**GRAYTHWAITE REHABILITATION CENTRE
RYDE HOSPITAL**

ACCESS REVIEW

Morris-Goding Accessibility Consulting

8th June 2011

Site Plan
1:500 @A1
20.05.11
3717-DA-001
50m

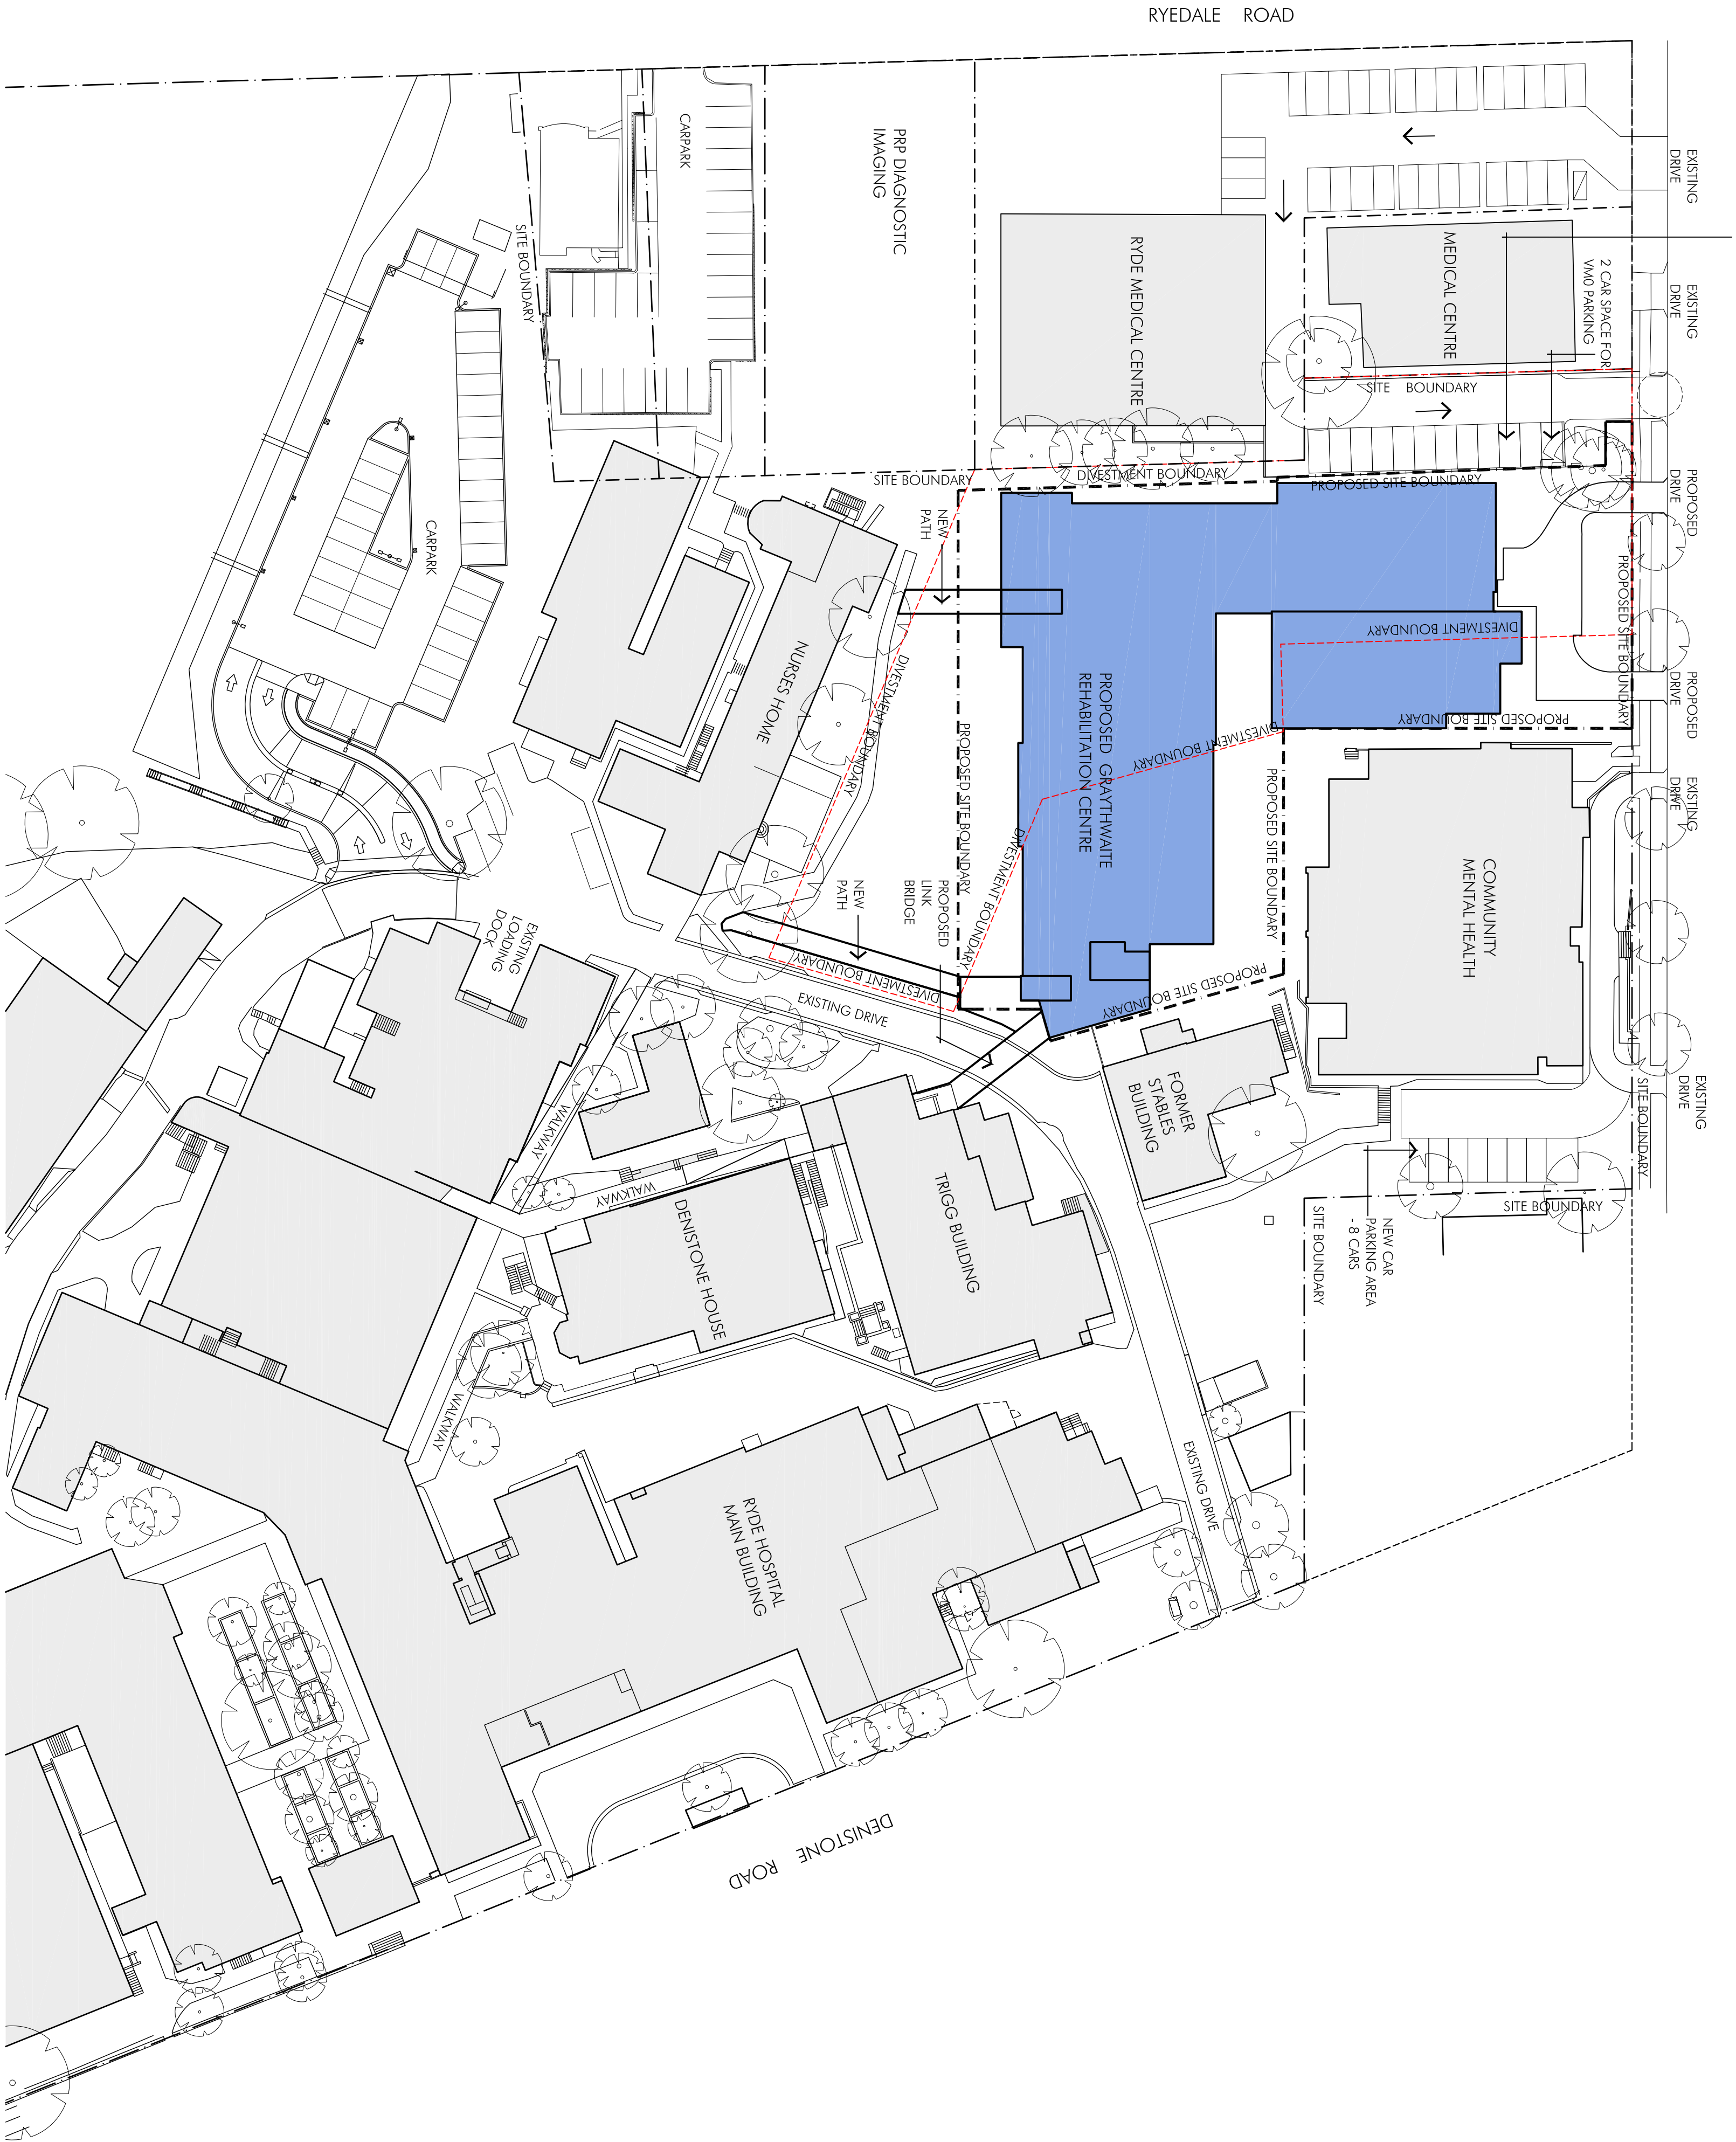
- (i) Ensure the connecting pathway to building main entry has a 1:20 min. gradient, compliant with AS1428.1.
- (ii) Ensure the active leaf of main entry doors provides 850mm clear width (generally 920mm door leaf), compliant with AS1428.1.
- (iii) Ensure a 1:8 kerb ramp, compliant with AS1428.1 is provided at patient drop off zone to enable wheelchair access from roadway to building entry.

This includes 4 designated accessible parking bays provided with dimensions of 3660mm min. clear width. This is in accordance with 4 % accessible car spaces required by Ryde Council DCP Part 5.16.1 for this type of development and exceeds BCA Table D3.5 and DDA Premises Standards requirements.

- (i) Ensure door from car park to entry lobby provides 850mm min. clear width (generally 920mm door leaf), compliant with AS1428.1.
- (ii) Provide 1540 x 2070mm min. circulation space at end of access way outside car park door for wheelchair manoeuvrability, compliant with AS1428.1.
- (iii) Ensure 2500mm min. height clearance over the accessible car spaces and 2200mm min. height clearance on path of travel from car park entry, compliant with AS2890.6.
